**ADC Planning Consultation
Conservation/Design Officer Response**

Application Number	AL/129/17/PL
Address	Land east of Forge House Nyton Road Westergate PO20 3UP
Description	Demolition of existing garage, demolition of portion of flint wall to re-instate pedestrian access onto Nyton Road & erection of 2 No. dwellings with associated car parking, cycle storage, bin storage & gardens. This application may affect the setting of a Listed Building.
Case Officer	Mr S Davis
Date	19 TH December 2017

project			
Forge House			
Nyton Road			
Eastergate West Sussex			
drawing			
Floor Plans and Indicative			
Street View			
As Proposed			
scale	date		
1:100, 1:125 @ A3	October 2017		
job no	drawing no	rev	
16078	02.02	A

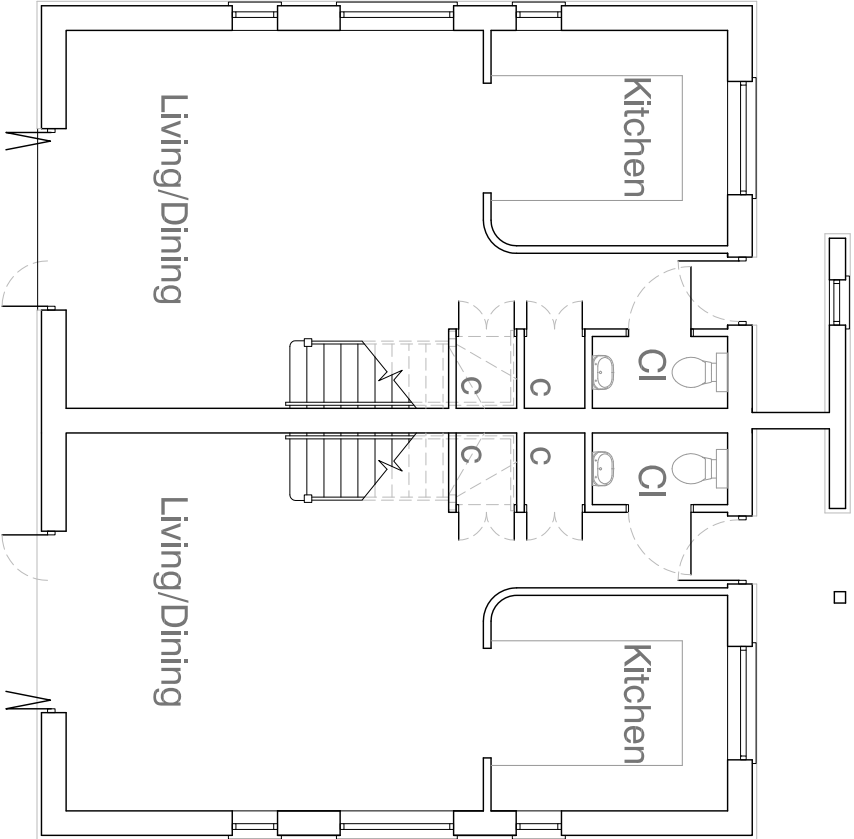
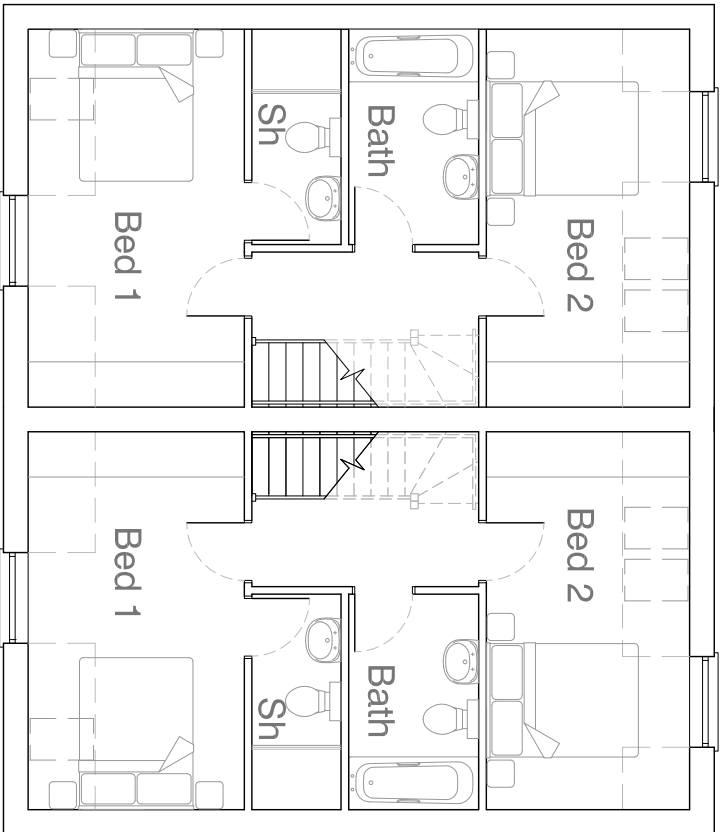
Forge House is surrounded by an original flint wall, detailed on the 1875-1890 map. At this time, Forge House is shown isolated in the landscape within this boundary. The wall is therefore an important contributor as evidence to the historic land scape and current street scene. The proposals detail removal of 24 linear metres of walling to create vehicular access. This is not supportable due to loss of the heritage asset. From the street elevation, there is no objection to the opening up of a previous aperture to provide pedestrian access, subject to detail of gate etc.

In general terms, the close proximity, massing, roof height and roofscape of the proposed dwellings are considered to be dominating, and unsupportable in the grounds of a Building of Local Character. The necessary landscaping, including hardstanding for multiple vehicles is considered to be detrimental to the setting of the heritage asset. The dominance of the proposed structure and associated works would dominate the streetscene and appreciation of the heritage asset.
